Recommendation: Refusal

Applicant: London And Regional Properties

Proposal: Non-Material Amendment to 17/02557/REM - 3 no. LPG tanks within the car park and updated hard and soft landscaping.

Project ATLAS (BICESTER) Ltd		Drawing Title LPG ENCLOSURE PLAN/ELEVATIONS	
Project BICESTER GATEWAY HOTEL			
Drawn Author	Date	Sheet Status S2 - FOR INFORMATION	
Checked Checker	Date	Project No. IALN1700034	
Scale As indicated @ A1		Drawing No. BGH-NOR-DE-A-6807	Rev. P01

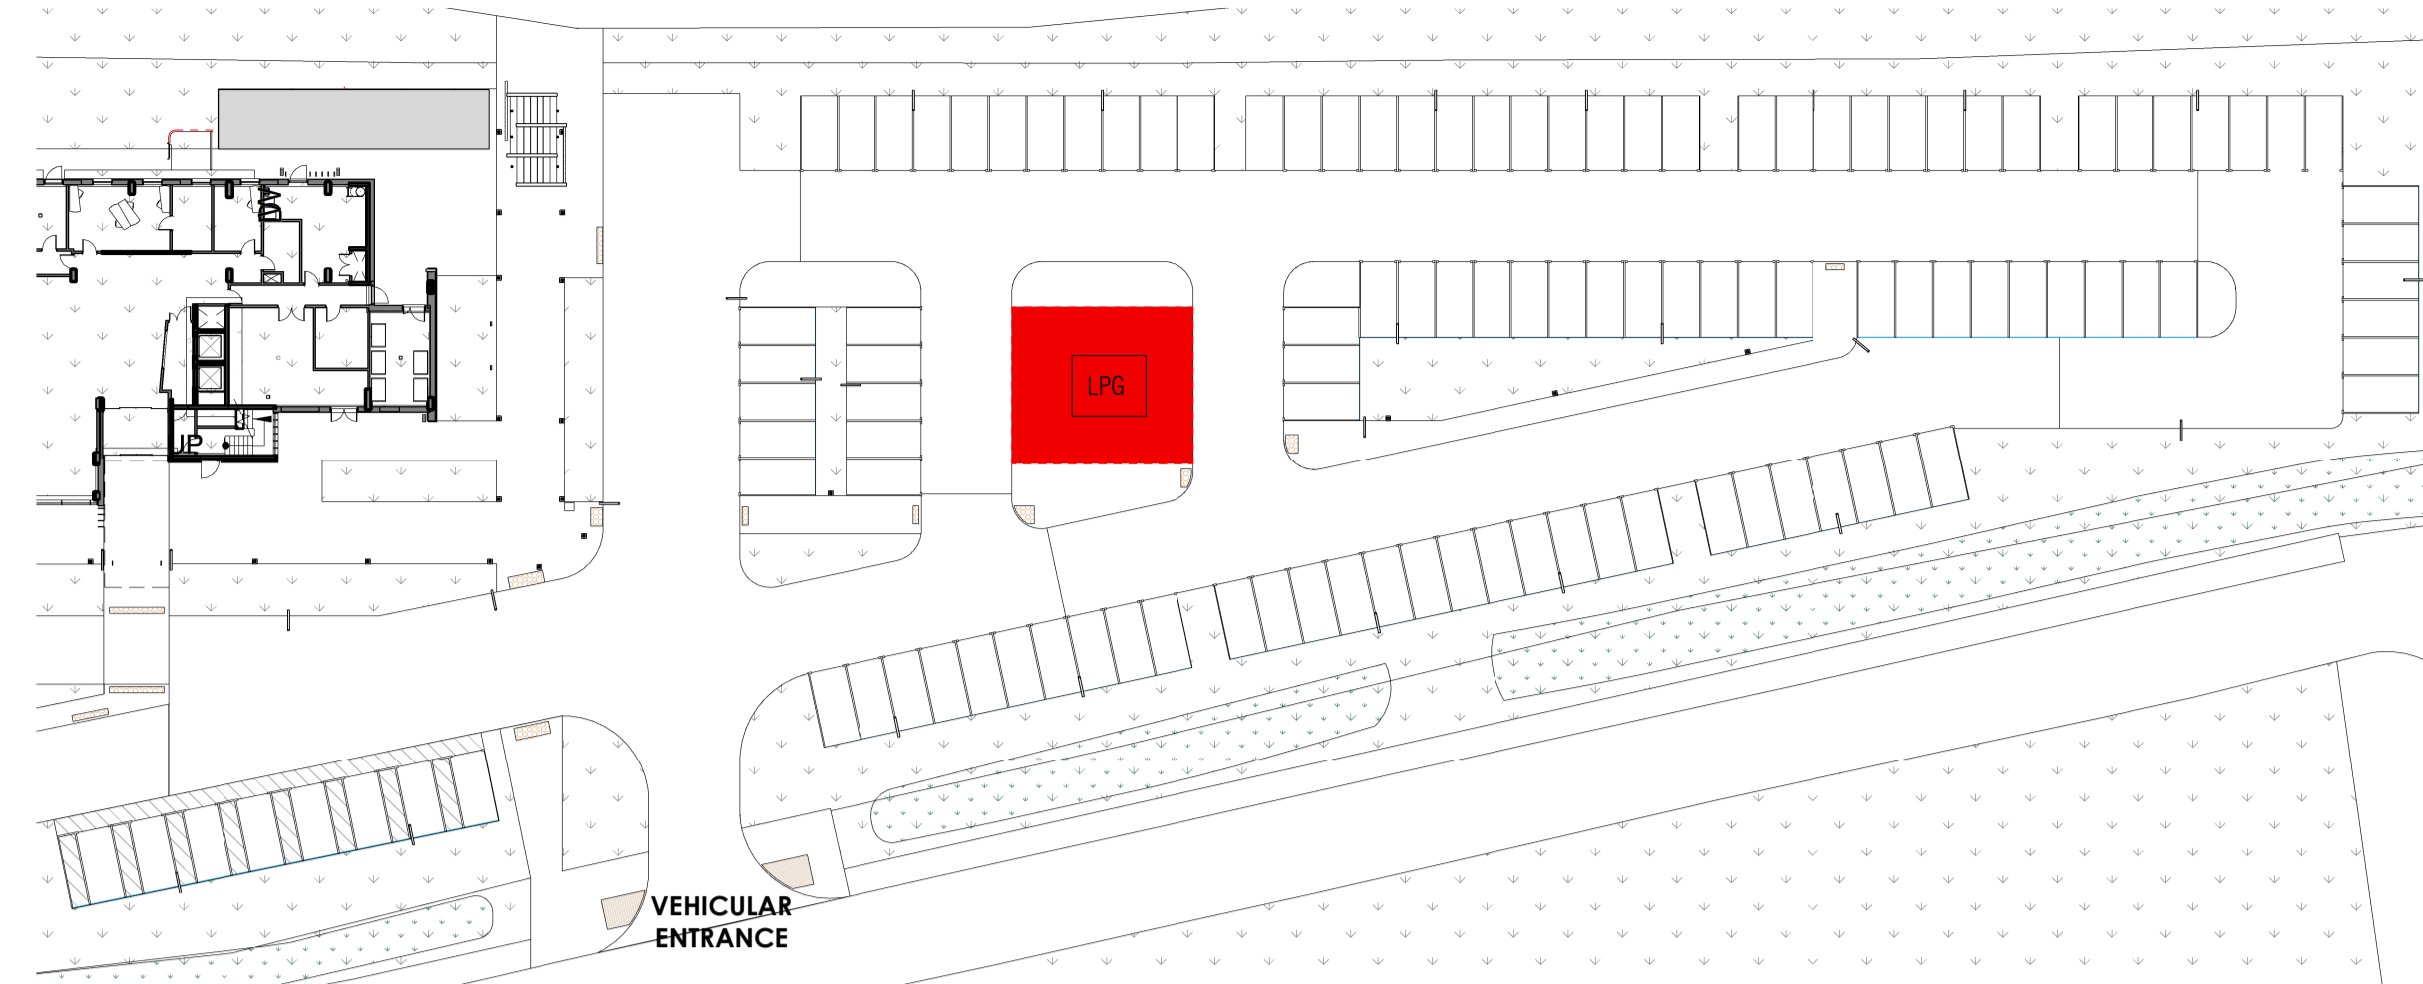
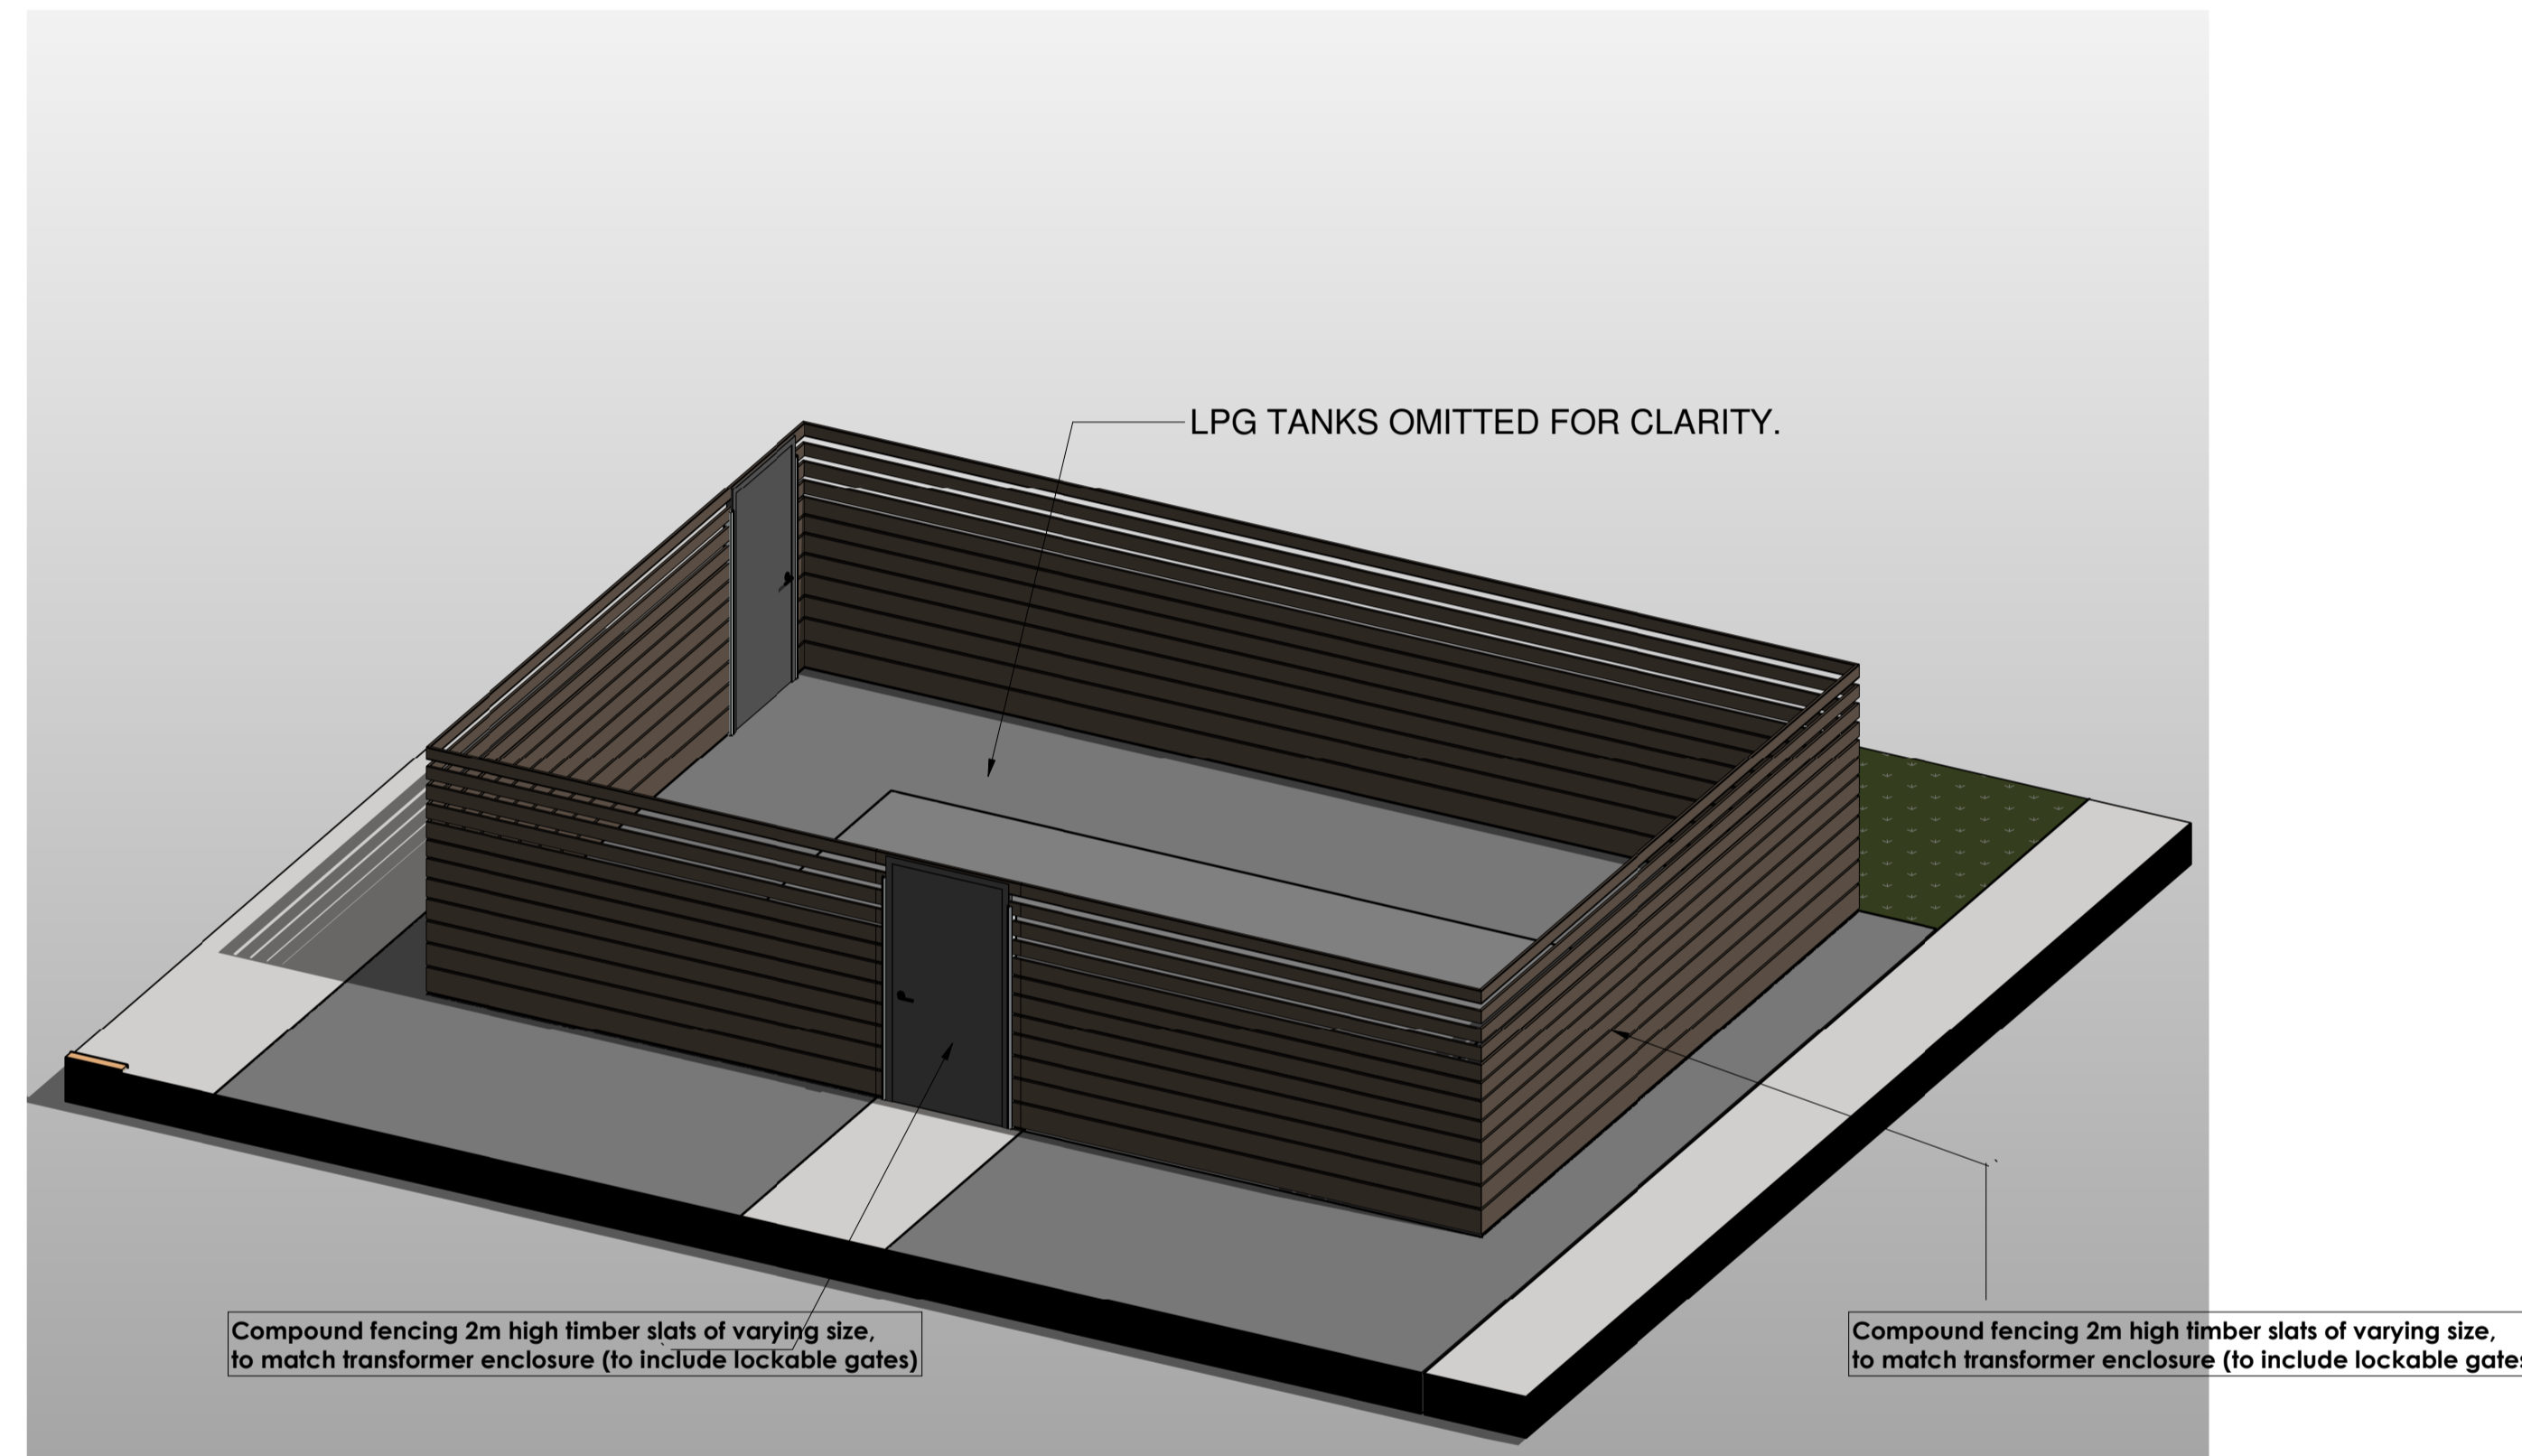
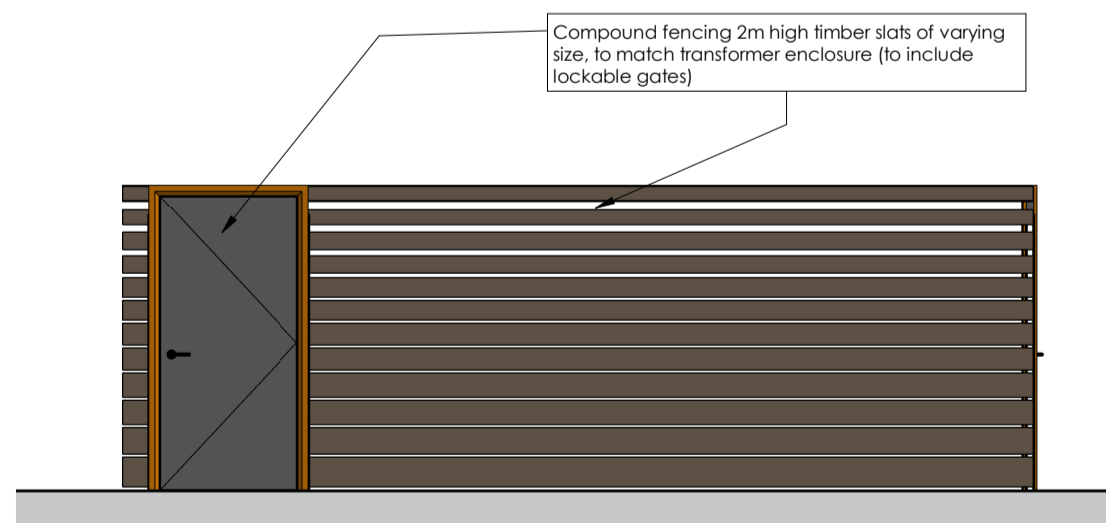
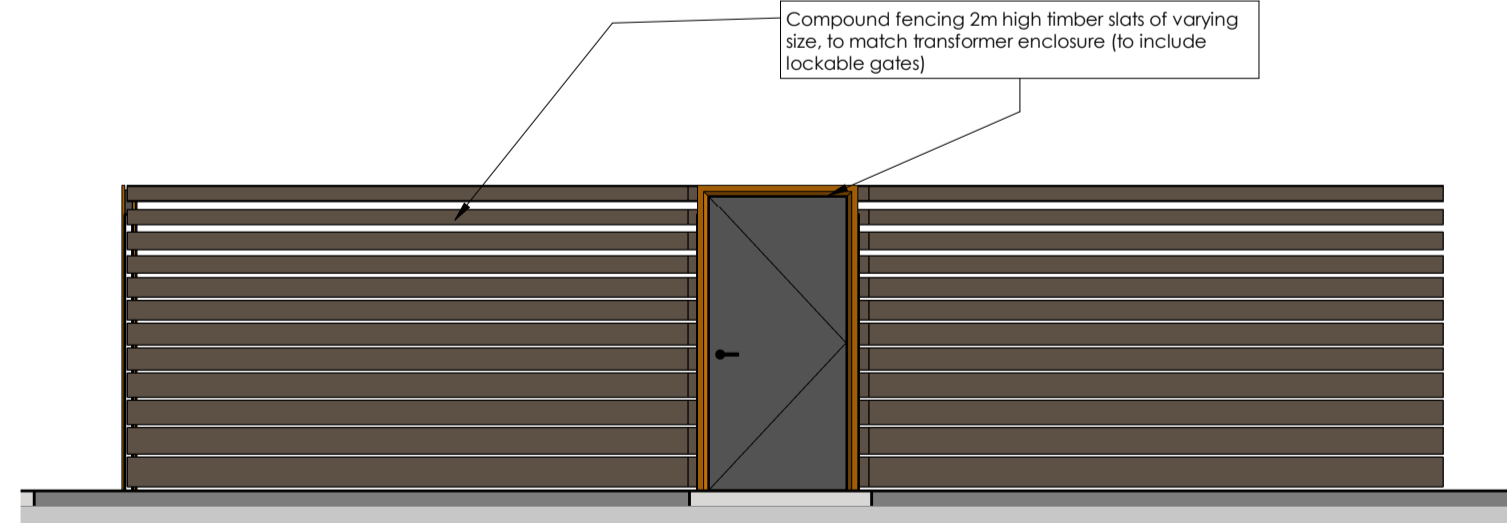
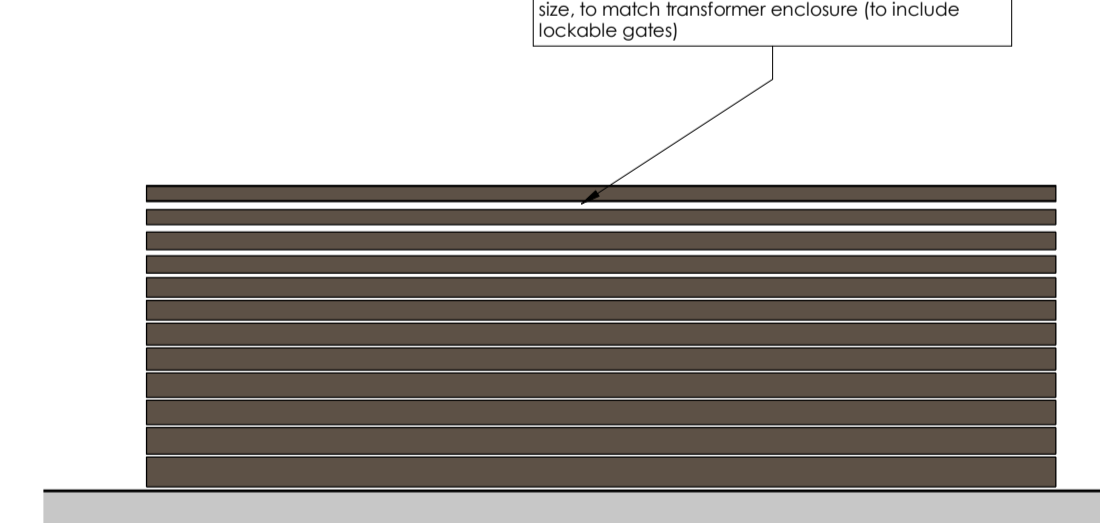
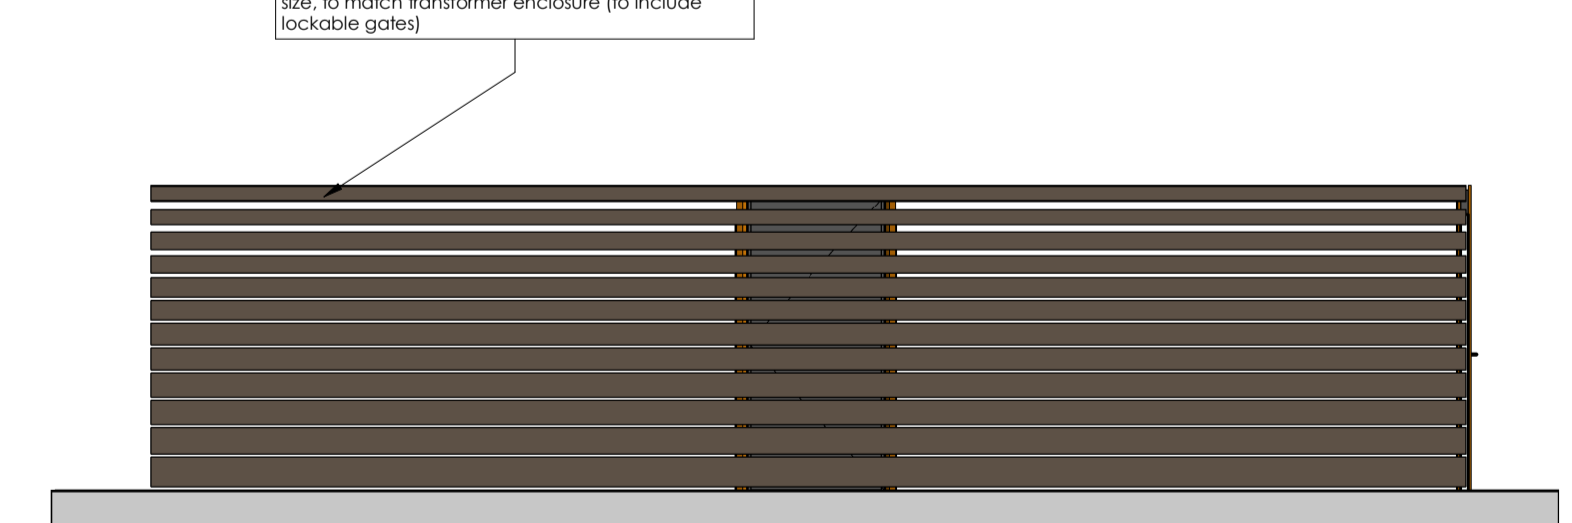
- 6.1. The application proposes to position the 3 LPG tanks within a central area of the approved car park, resulting in the loss of 9 car parking spaces. The LPG tanks would be surrounded by fencing at 2m in height. In addition, the proposal seeks to amend the proposed surfacing materials from predominantly block paving to predominantly a combination of porous and non-porous tarmac.

- 6.2. In my view the changes proposed are material. The addition of the LPG tanks in the car parking area would need consideration through a planning application process to consider issues such as the loss of car parking and the impact of the associated hard and soft landscape changes (such as the use of gravel, which the Highway Authority may have concerns in relation to). In addition, the change to the surfacing material represents a change to the drainage scheme (approved by conditions attached to the outline permission) by reducing the area of porous surface (as more non-porous tarmac is proposed) and this should be assessed further including through a consultation with the Lead Local Flood Authority. In addition, the visual impact of the loss of block paving and its replacement with tarmac would need full consideration. It is also noted that a number of plans proposed to be amended by this application are referred to within various conditions meaning that amendments to the wording of those conditions would also require amendment. A non-material amendment, by its nature, should not require assessment such that it impacts material planning considerations that technical consultees would need to input into.

- 6.3. Furthermore, I do not consider the proposal to be acceptable in any event. The proposed LPG tanks surrounded by 2m high timber fencing will be an unacceptable feature in the middle of the car parking area in visual impact terms in my view. This combined with the loss of block paving in the car parking area and its replacement with more tarmac has the potential to reduce the quality of the car parking area.

The proposed addition of 3 no. LPG tanks surrounded by 2m high timber fencing within the middle of the car parking area and the updated hard and soft landscaping proposals are considered to be a material change to the approved development. The proposed amendments cannot therefore be accepted as a non-material amendment under Section 96A of the Town and Country Planning Act 1990 (as amended).
